4. **Project# 1008042**
11DRB-70308 EPC APPROVED SDP
FOR BUILD PERMIT

INTER-OFFICE MEMO

DATE: October 10, 2011
TO: Jack Cloud, DRB Chair
FROM: Catalina Lehner, Senior Planner *cl*
RE: Project #1003532, La Cueva Area Auto Care
Site Development Plan for Subdivision
Site Development Plan for Building Permit

ENGINEER'S SEAL	FIRESTONE PASEO DEL NORTE & WYOMING BLVD	DRAWN BY JH
		DATE 11-03-11
	DETAILS	2995-DETAILS
	TERRA WEST, LLC 5571 MIDWAY PARK PLACE NE ALBUQUERQUE, NM 87109 (505)858-3100 tierrewestllc.com	SHEET # C5
RONALD R. BOHANNAN P.E. #7868		JOB # 29095

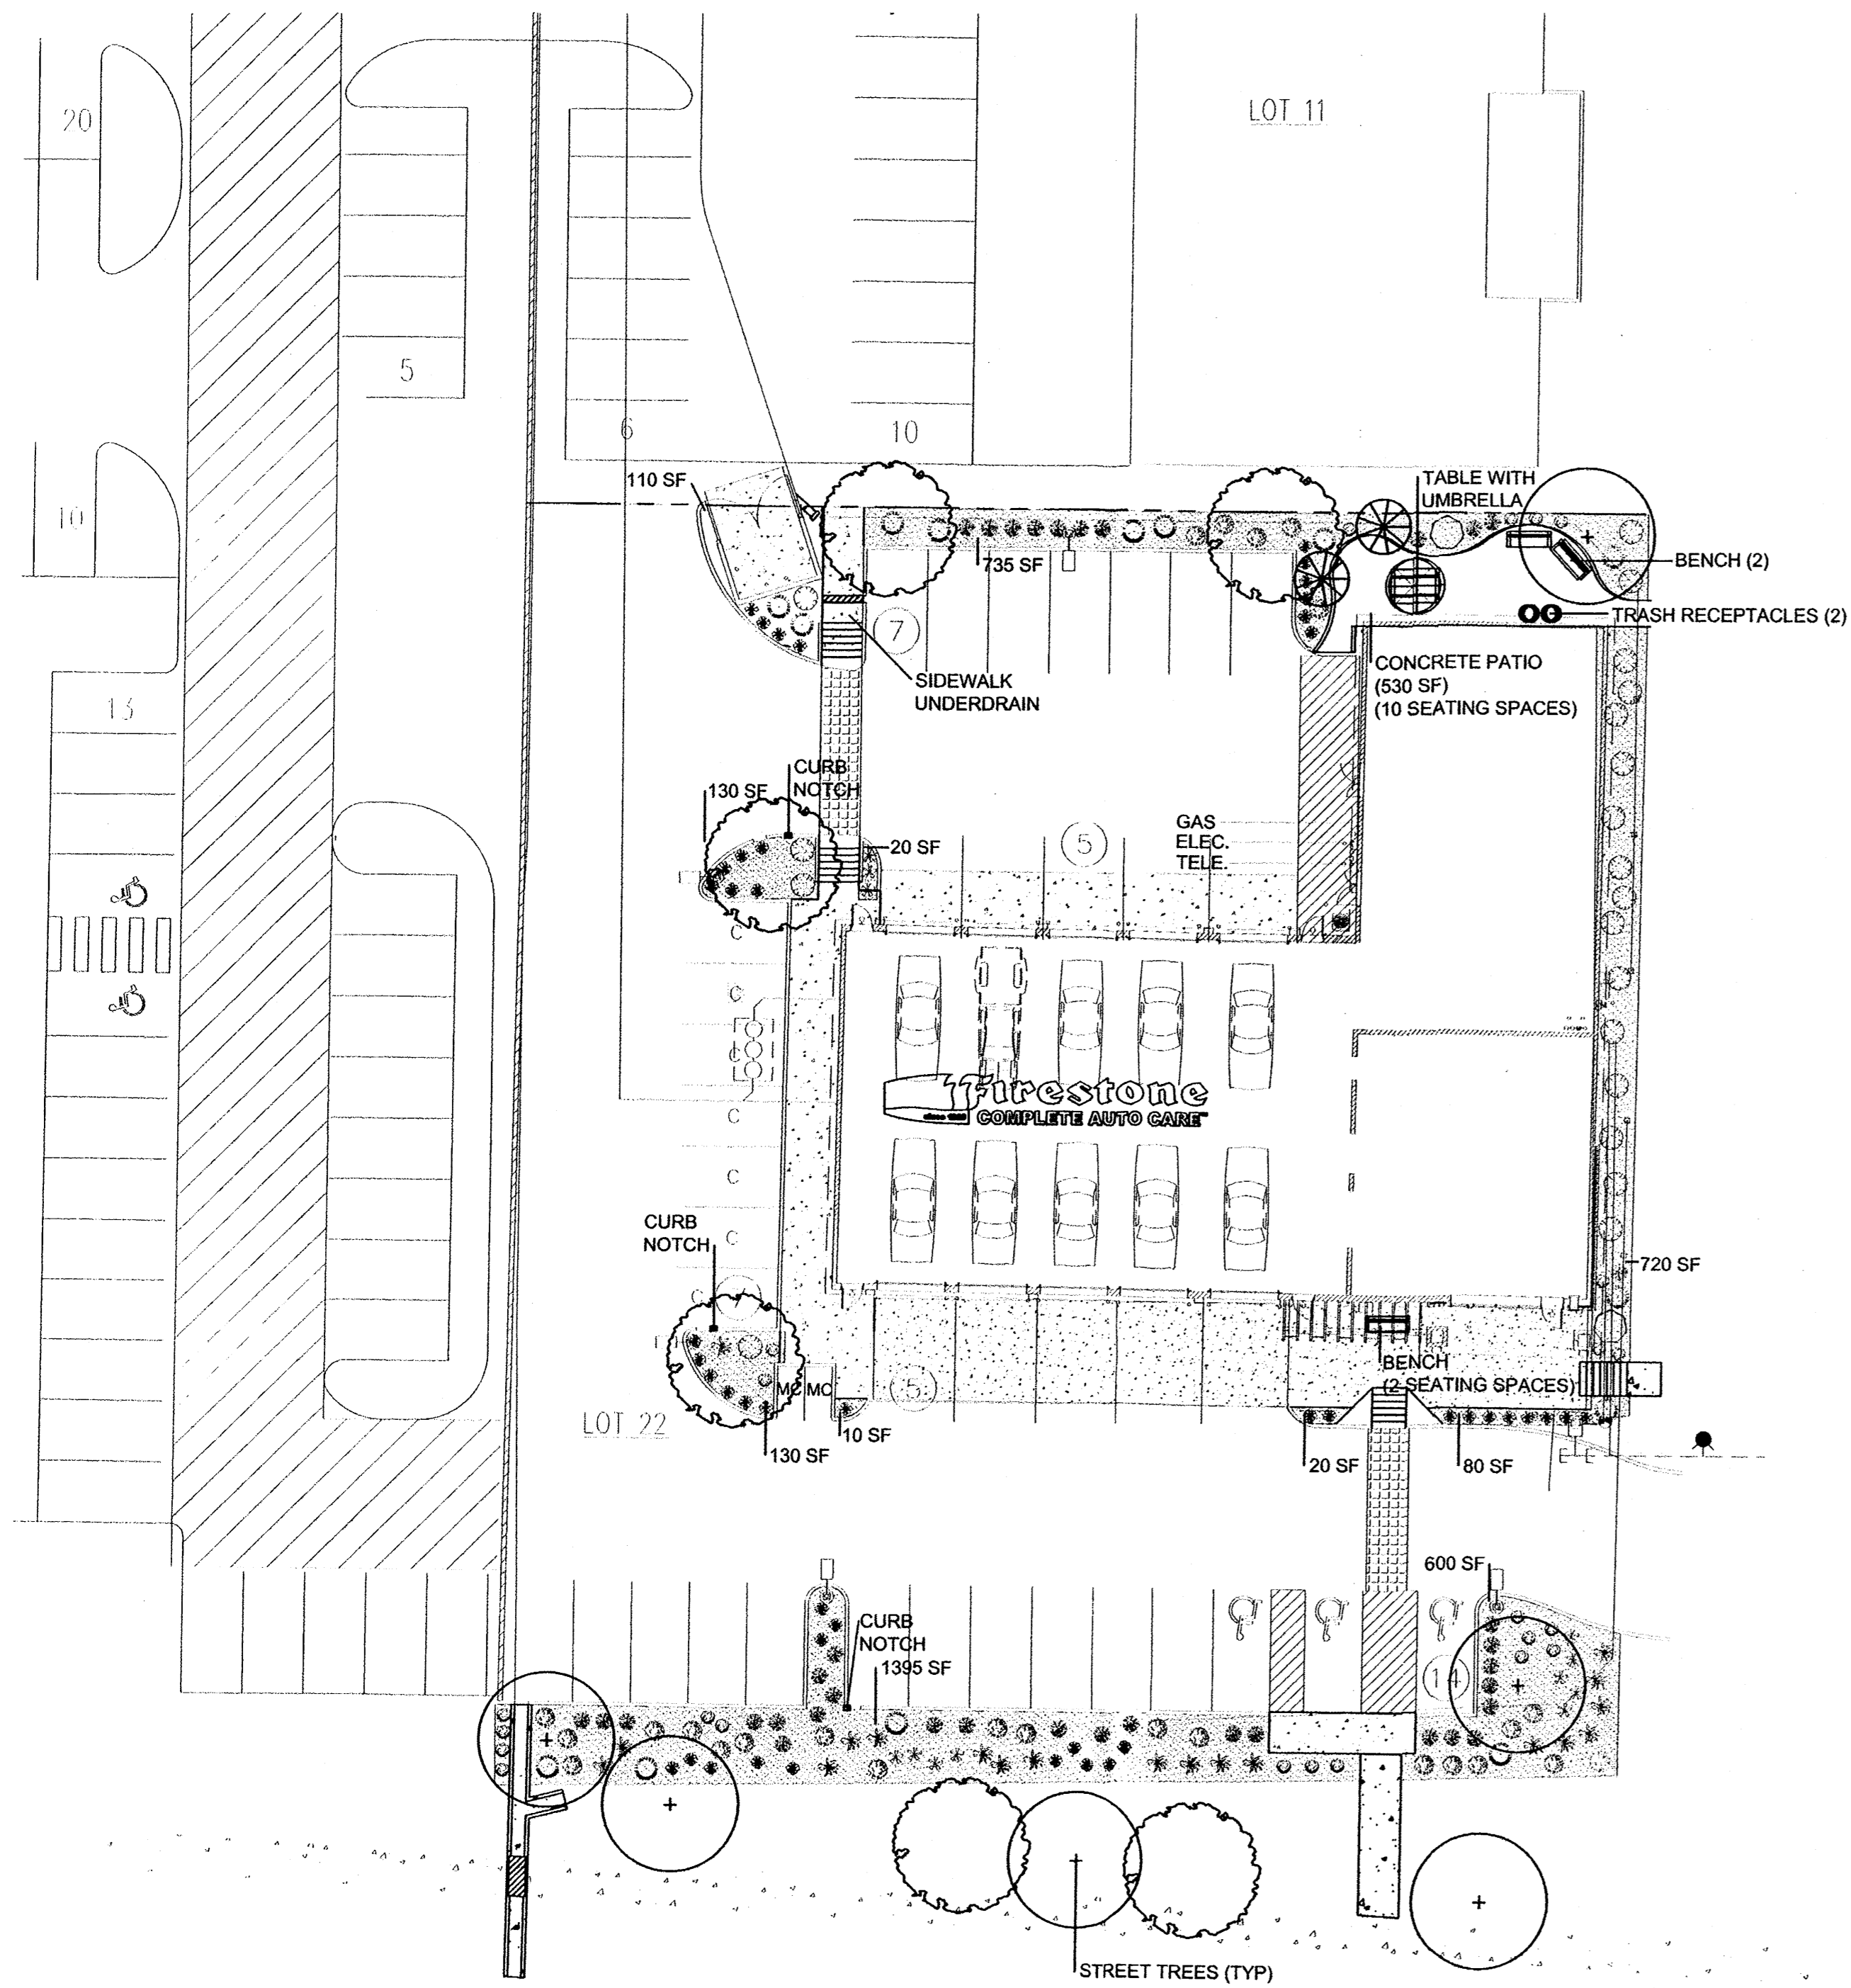
Condition #6A: Dimension the pedestrian pathway on sheet C-2 and on the detail sheet. (for #6A and #6B- the detail says "raised crosswalk" and should also be labeled as "pedestrian pathway" so there is clarity).

Condition #11A: Specify sign lighting on the sign detail.

6 (NORTH) ELEVATION
SCALE: 1/8" = 1'-0"

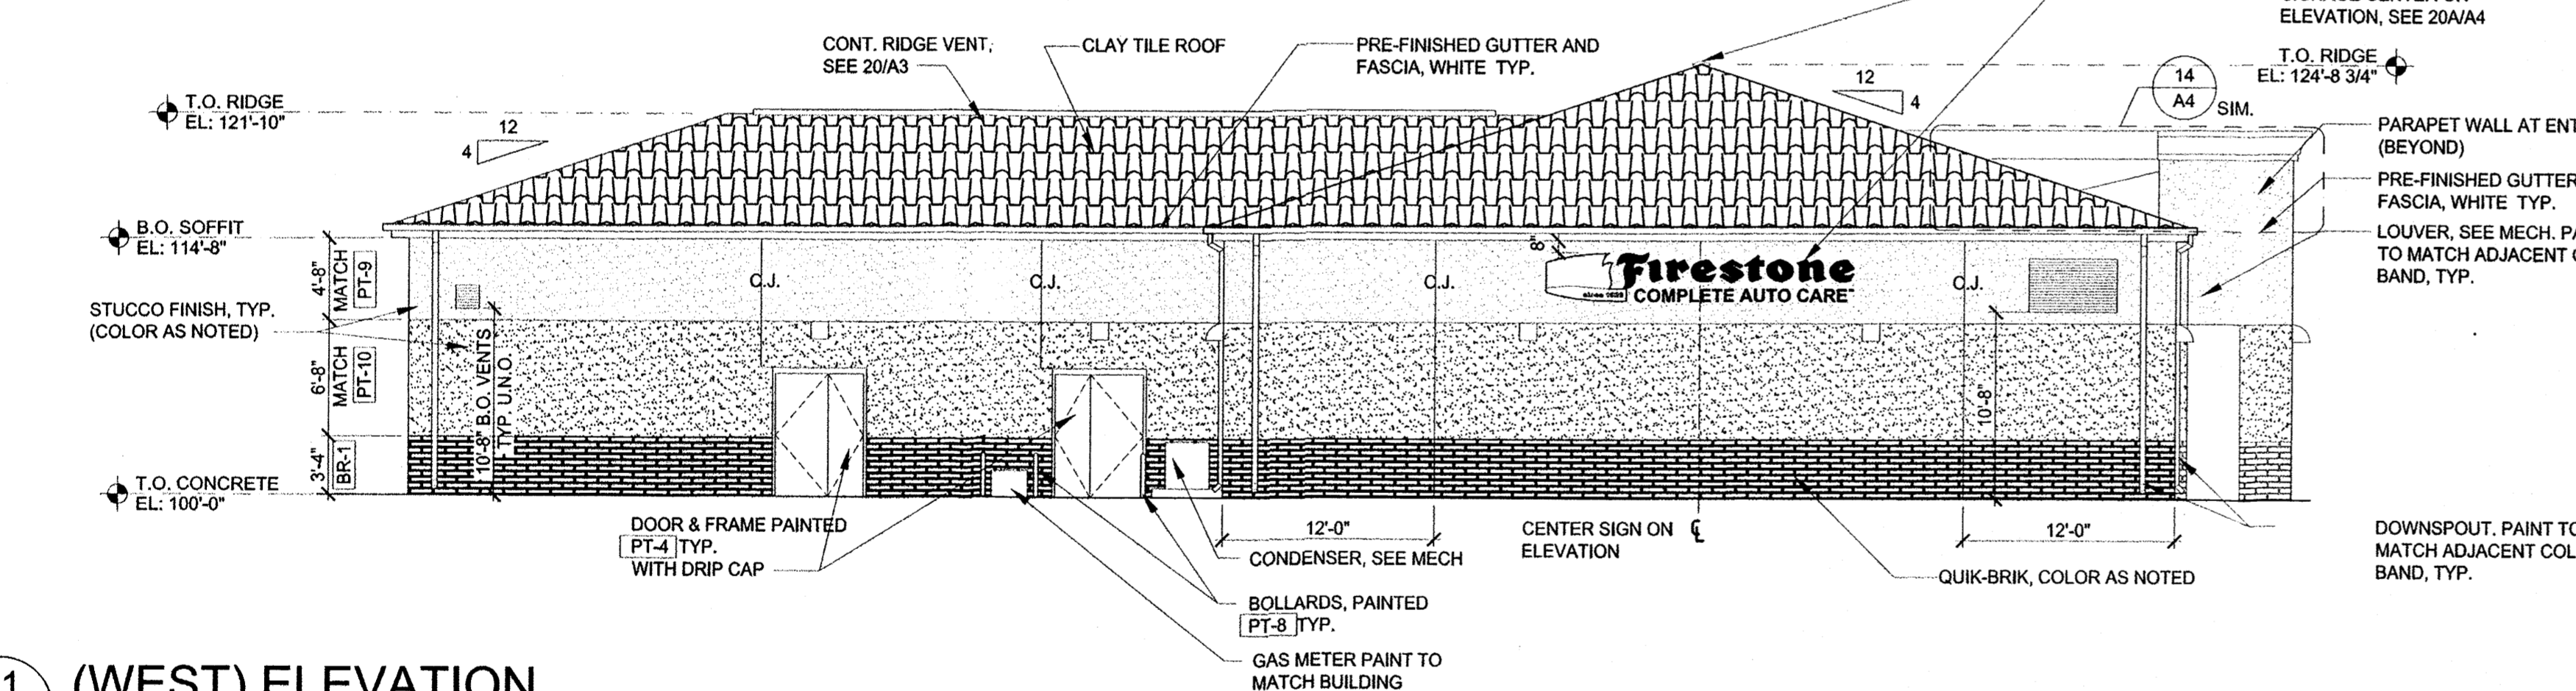
Condition #9C: Additional wall-mounted lights have not been added as the condition requires. At least 3 should be added to the eastern elevation, which is the only elevation without any lighting.

Condition #10B: (see email from Carmen, dated 8-23-11). The email says that there was an agreement to do a combined trellis/canopy. However, the combined trellis/canopy is not shown on the elevations- only the trellis is, so the agreement was not adhered to. Elevations need to be revised to reflect the agreement. Also, sheet C-2 needs to be labeled to indicate that the space near the main entrance is a trellis/canopy.
